Rezoning Transportation Analysis

Petition Number: 2020-035

General Location Identifier: Tax ID 04711201

Date	Description
03-25-20	First Review
04-23-20	Second Review

RZ-2

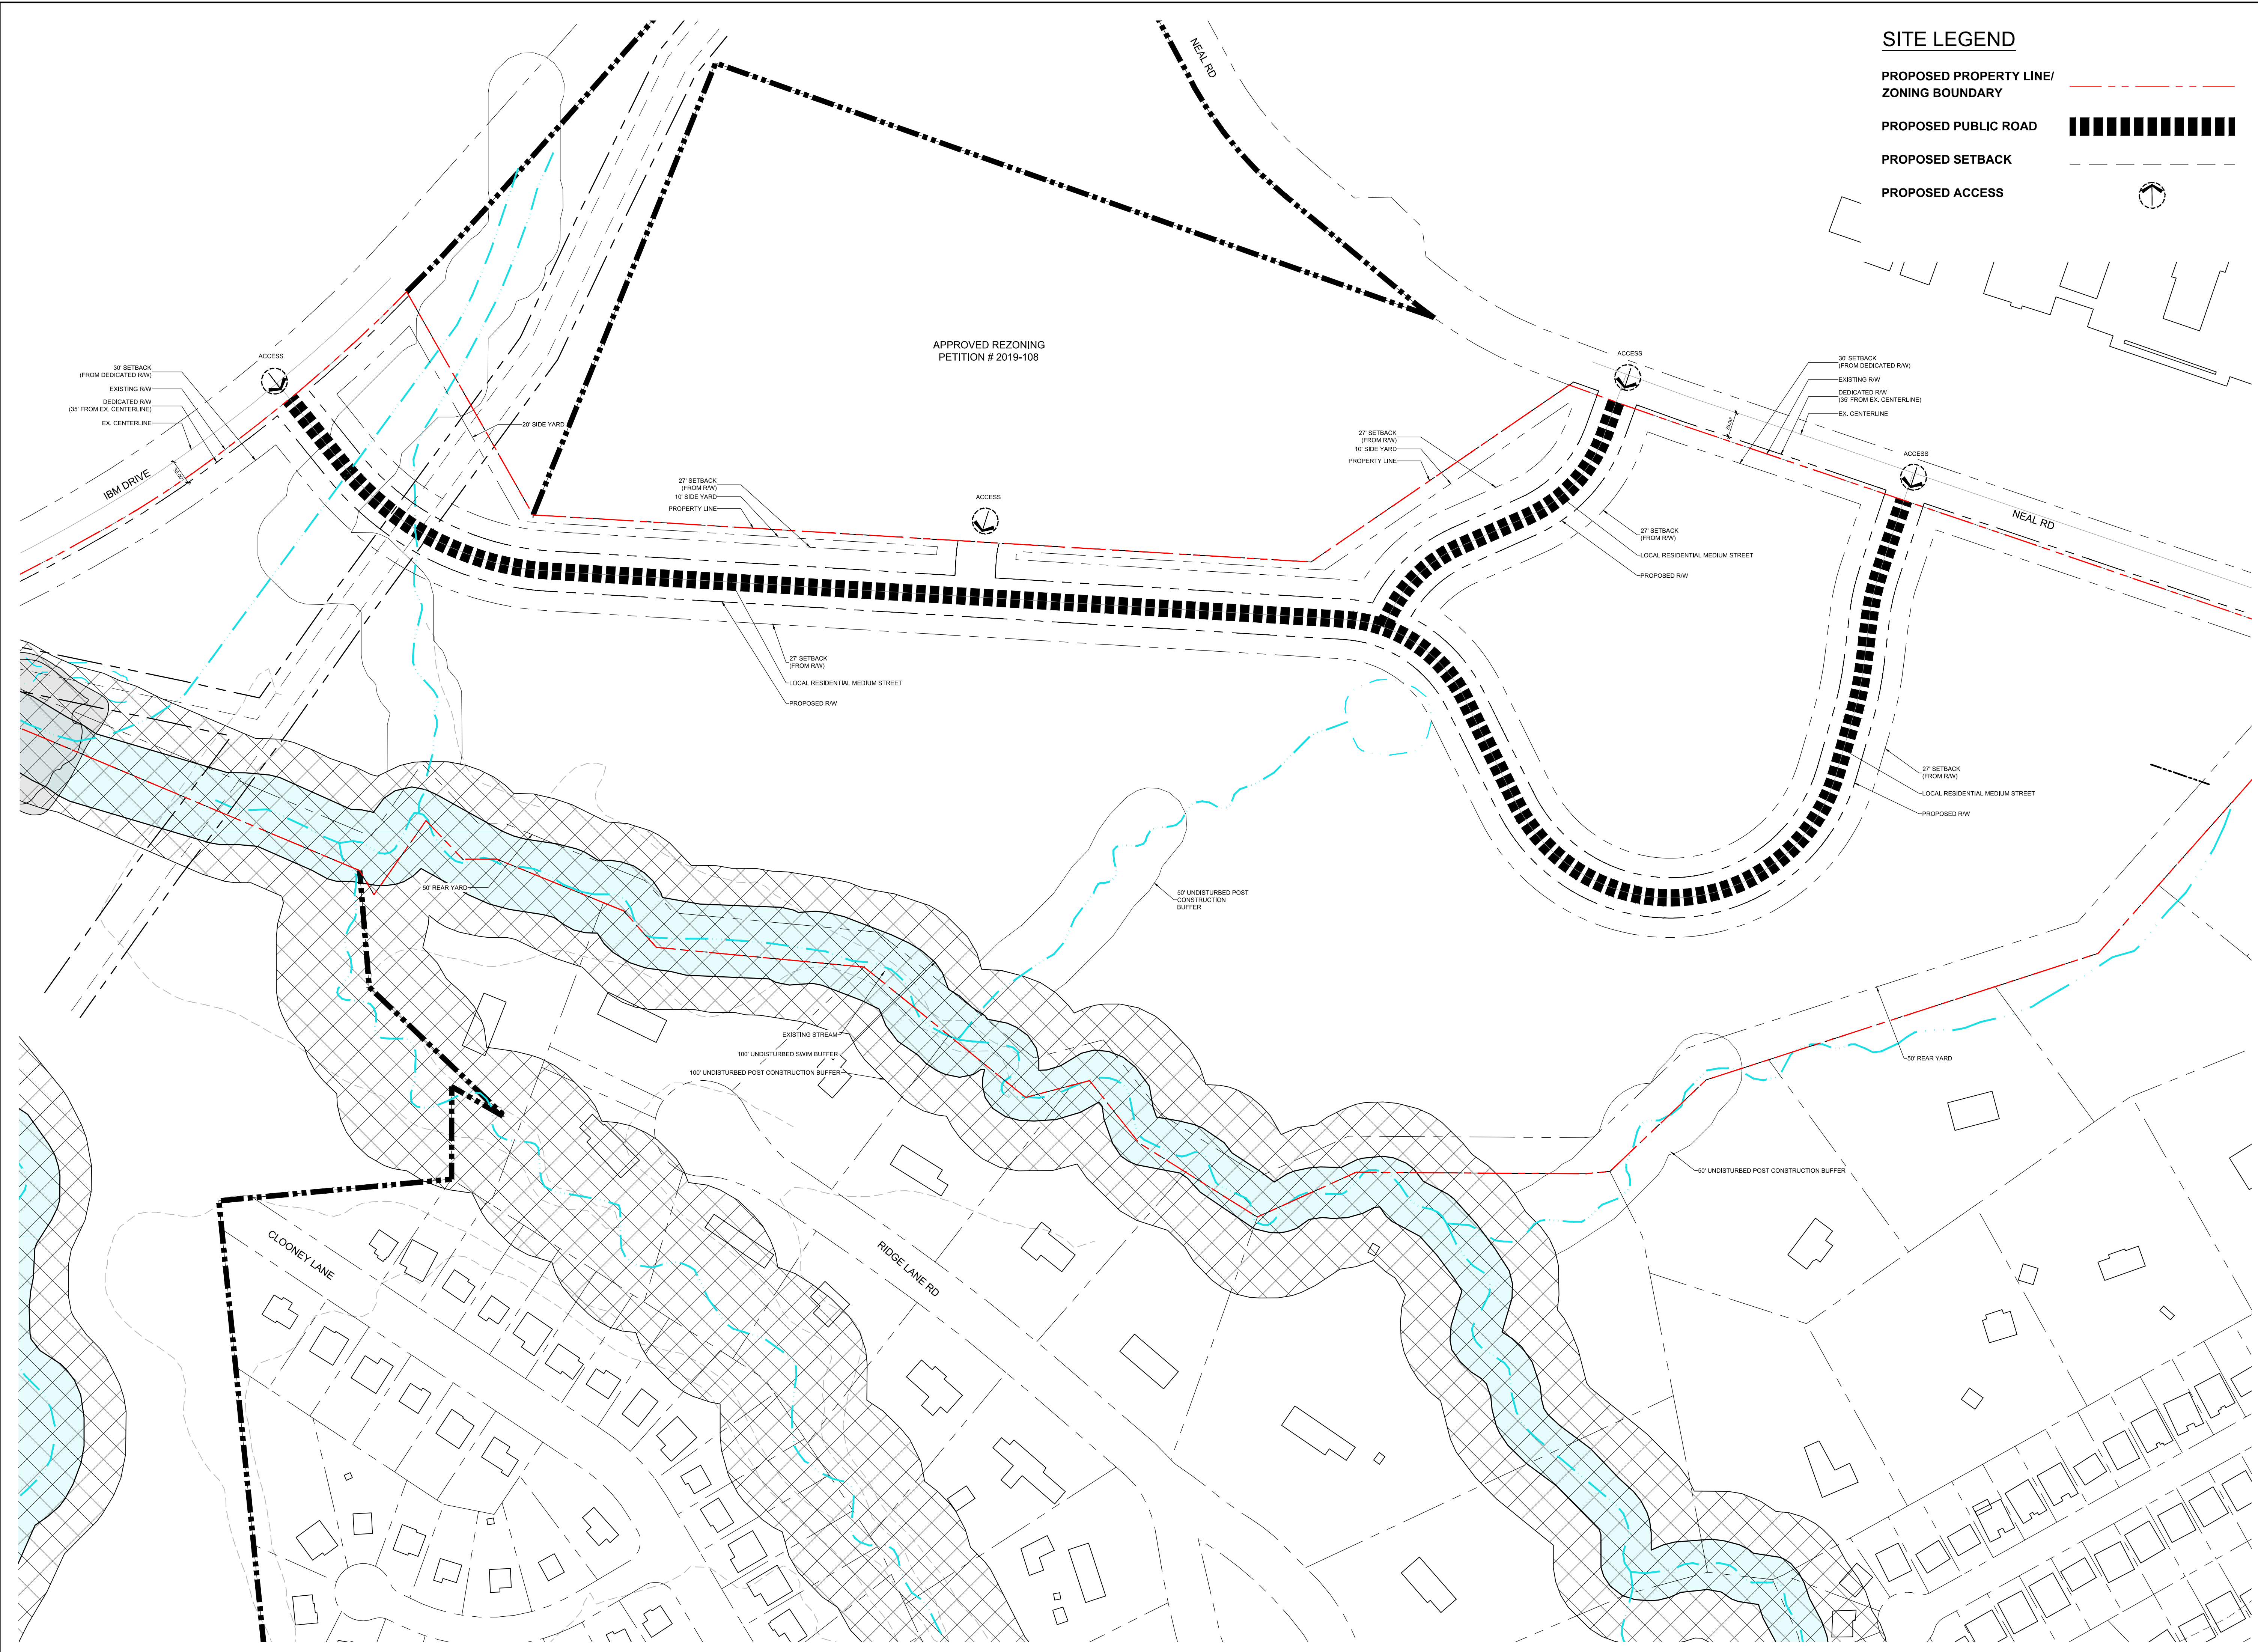
The site plan should show the curb and gutter labeled and dimensioned from the centerline for each road.
2. **Traffic Study** A Traffic Impact Study is typically necessary for a proposed development, if the site generates 2500 daily trips. In this case, the site will be fourth leg of a signalized intersection at IBM Drive, therefore, it triggers a traffic impact study under CDOT Traffic Impact Study Guidelines.

3. The petitioner should revise the site plan and conditional note(s) to commit to dedicate 35' of right-of-way from the road centerline for Neal Road and IBM Drive. The site plan should label and dimension the right-of-way from the road centerline.

4. The petitioner should revise the site plan and conditional note(s) to commit to construct the proposed access point on Neal Road across the existing school driveways.

- a. The most norther driveway on Neal Road is too close to the recently approved driveway as part of rezoning petition 2019-108 because it doesn't even provide the ability for a 150' storage for a length turn lane.

- b. The petitioner needs to provide an existing queuing analysis for the school driveways on Neal Road to fully understand the traffic situation and to adequately locate the driveways.

- c. The site plan should show the adjacent and across the street driveways on Neal Road and IBM Drive to identify vehicular conflict points.
5. The petitioner should revise the site plan and conditional note(s) to locate the required Subdivision collector street within the site further away from its proposed location to the driveway for approved rezoning petition 2019-108. The collector can be either of the proposed streets showing a connection to Neal Road.

6. The petitioner should revise the site plan and conditional note(s) to commit to installing curb and gutter along Neal Road and IBM Drive, as required by Chapter 19th ordinance on thoroughfares and multi-family land use.

7. The petitioner should revise the site plan and conditional note(s) to commit to connect the street stub from rezoning petition 2019-108 to the proposed public street.

8. The petitioner should revise the site plan and conditional note(s) to provide local collector road as part of this petition, and as required by the Subdivision ordinance. Please provide a typical for the local collector road typical.

9. The petitioner should revise the site plan and conditional note(s) to commit to construct an 8-foot planting strip, and 6-foot sidewalk on Neal Road and IBM Drive. The site plan should label and dimension both items from the back of curb and gutter and road centerline.
